**Canmore Lodge Owners Comments on:**

**22/01109/FUL**

**Demolition of Existing House and Outbuildings and Construction of Replacement House and  
Garage - High Ridge Top Street Askham Newark Nottinghamshire NG22 0RP**

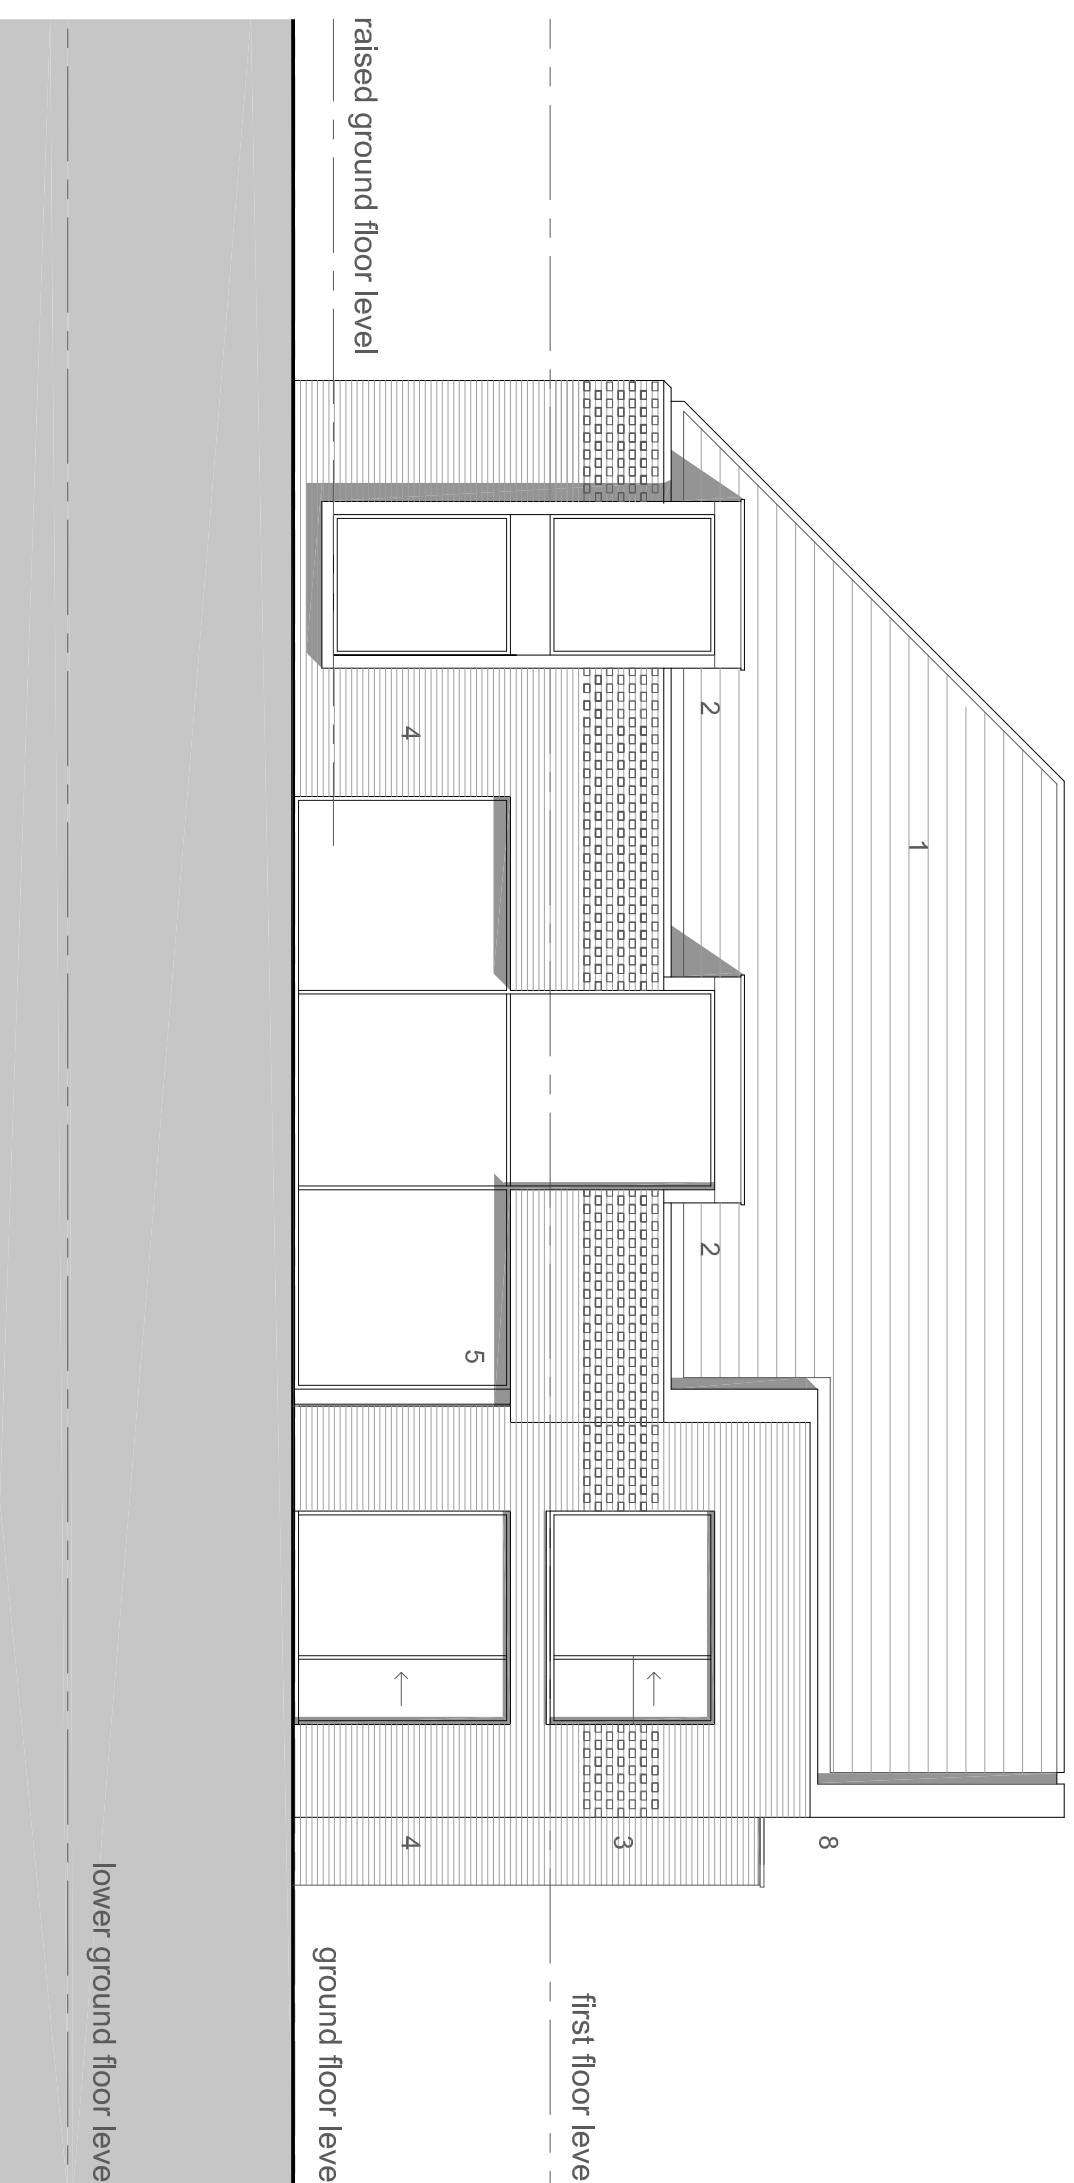
We are very concerned that the extensive glazing on the South facing aspect of the property will result in significant glare / reflection of sunlight during the day and light pollution at night. The existing windows of the property can cause some glare / reflection during sunny days, however the proposed design would amplify this many times over due to the extensive use of glass and the proposed elevation of the glazing.

Height and Massing study in relation to neighbouring houses

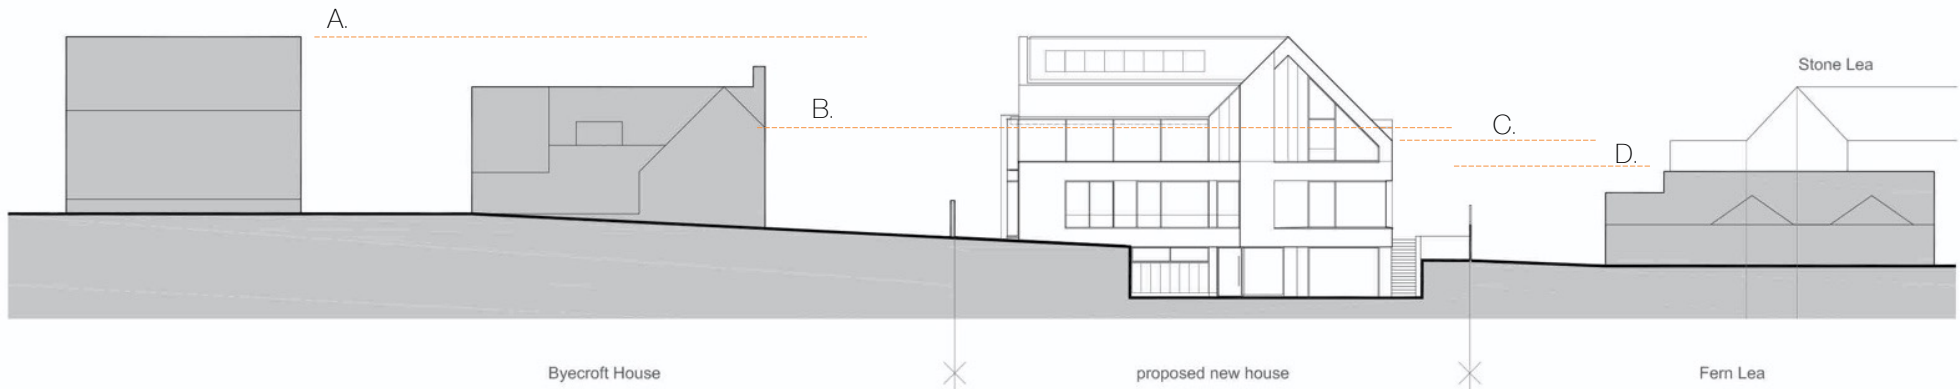
The 'Design and Access statement' tries to justify the ridge height as follows:

*"The design and the heights of neighbouring buildings have informed the design:*

- A. The ridge height of the new property to the west of Byecroft House has been set as the ridge for the new property. "*

As can be seen from the above representation, the building will not sit comfortably with its neighbours with it being considerably larger and higher. The building replaces a single story dwelling with a 3 storey dwelling. The design refers to a 'Lower Ground floor', this terminology appears to be intentionally misleading - The term 'ground level', or 'ground floor', is used to refer to the level of a building that is at ground / street level, which in the case of this proposed building is the lowest level. The building does not compliment the surrounding buildings (see point 4).

Top Street drops in elevation towards the centre of the village (from west to east). A more appropriate and acceptable ridge height would be to align to the ridge height of Bycroft house less the natural fall of the road – which is exactly the Ridge height of the existing building at 58m above sea level.

1. The maximum development height of 'High Ridge' to be retained at 58m. This is the same height as Byecroft house, less the natural drop in the road.
2. The historically significant coach house to be retained and incorporated into the design.
3. For the main house to be redesigned to use local materials and local design inspirations which will complement the architectural styles within Askham. This should primarily focus on a reduction in glazing which will reduce the privacy impact on neighbours.
4. A detailed proposed site topography to be issued with any future applications.
5. For the developer to explain why the ecology study is redacted – specially in relation to bats
6. A commitment to undertake 'genuine' local engagement.
7. A revised Design and Access statement which corrects the numerous errors highlighted in these comments.
